**DEVIATION REVIEW
 AND DECISION FORM**

Subdivision or Project Name: The Shops at Meridian Ranch

Section of ECM from Which Deviation is Sought: 2.2.5.D Roadway Access Criteria Collector Access Standards and Table 2-7 Roadway Design Standards for Urban Collectors and Locals.

Proposed Nature and Extent of Deviation: The deviation is a request is to allow for an access (a full-movement access) to Tourmaline Drive (a Collector) 257 feet east of Meridian Road (a Principal Arterial).

DRAWING NO.
1
 SITE DEVELOPMENT PLAN

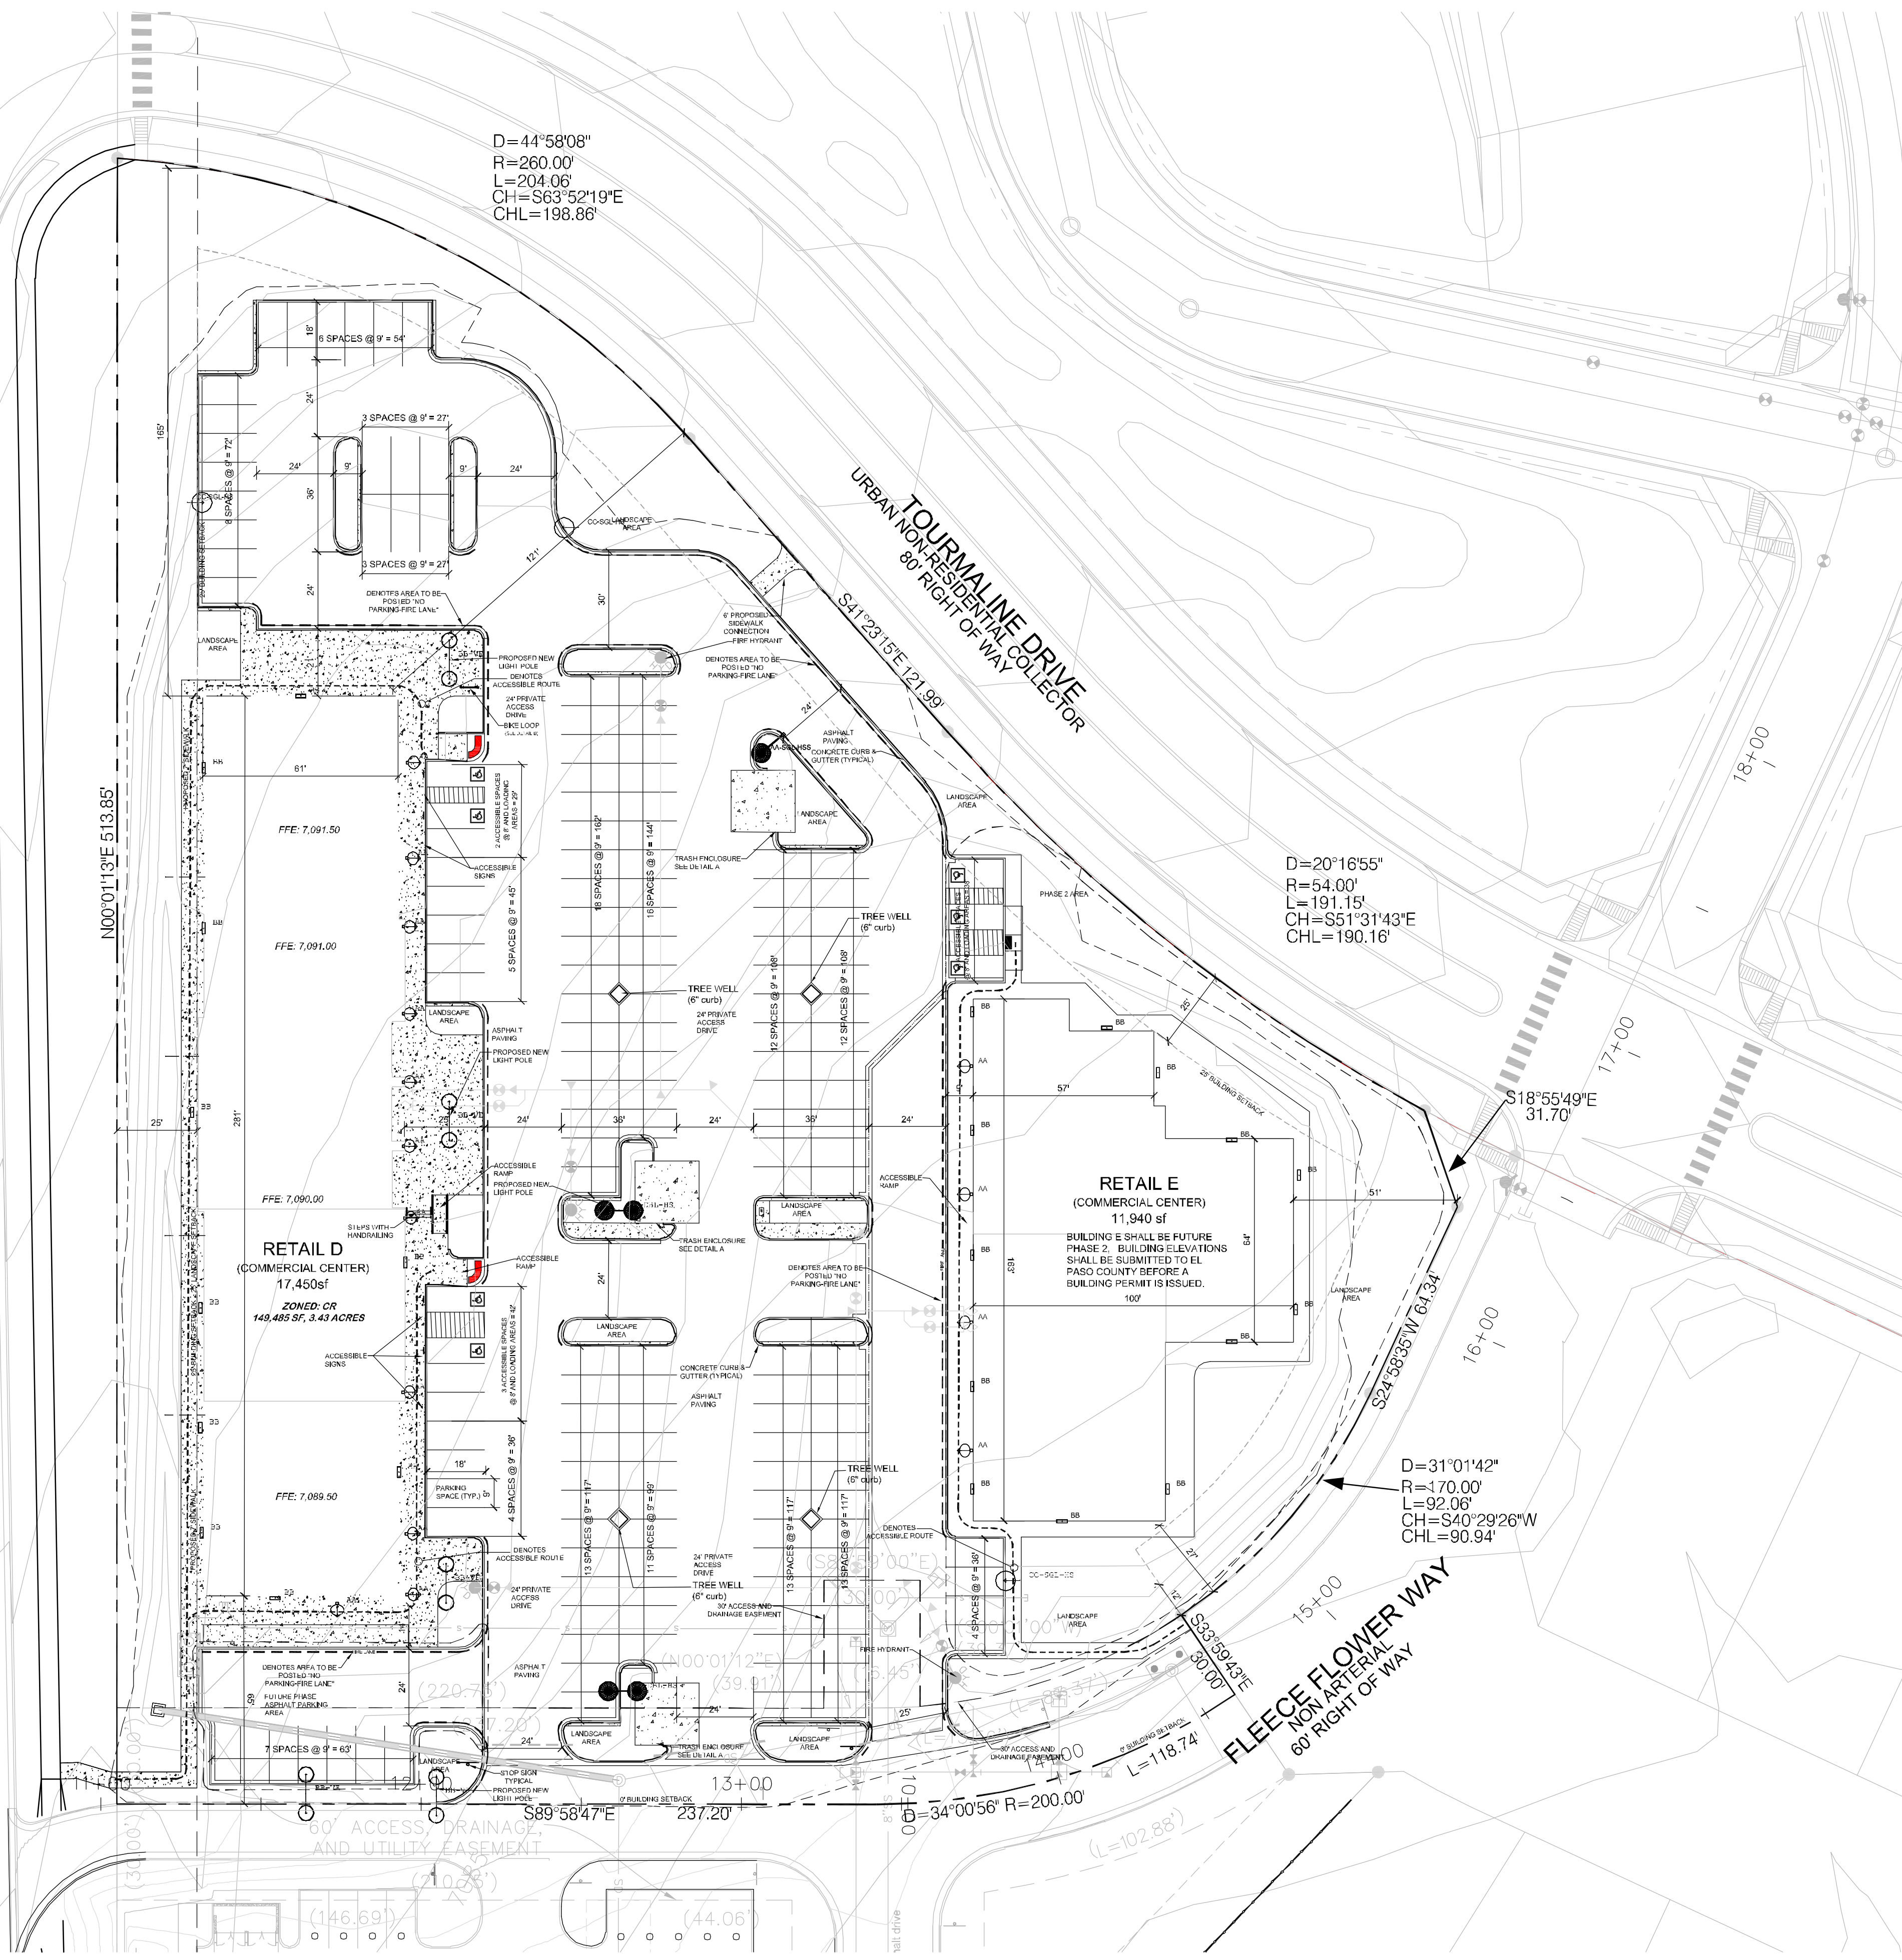
This deviation request is likely to be denied due to concerns with the entering sight distance to Tourmaline Drive. Consider revising the proposed full movement access. With the re-submittal provide supporting exhibits.
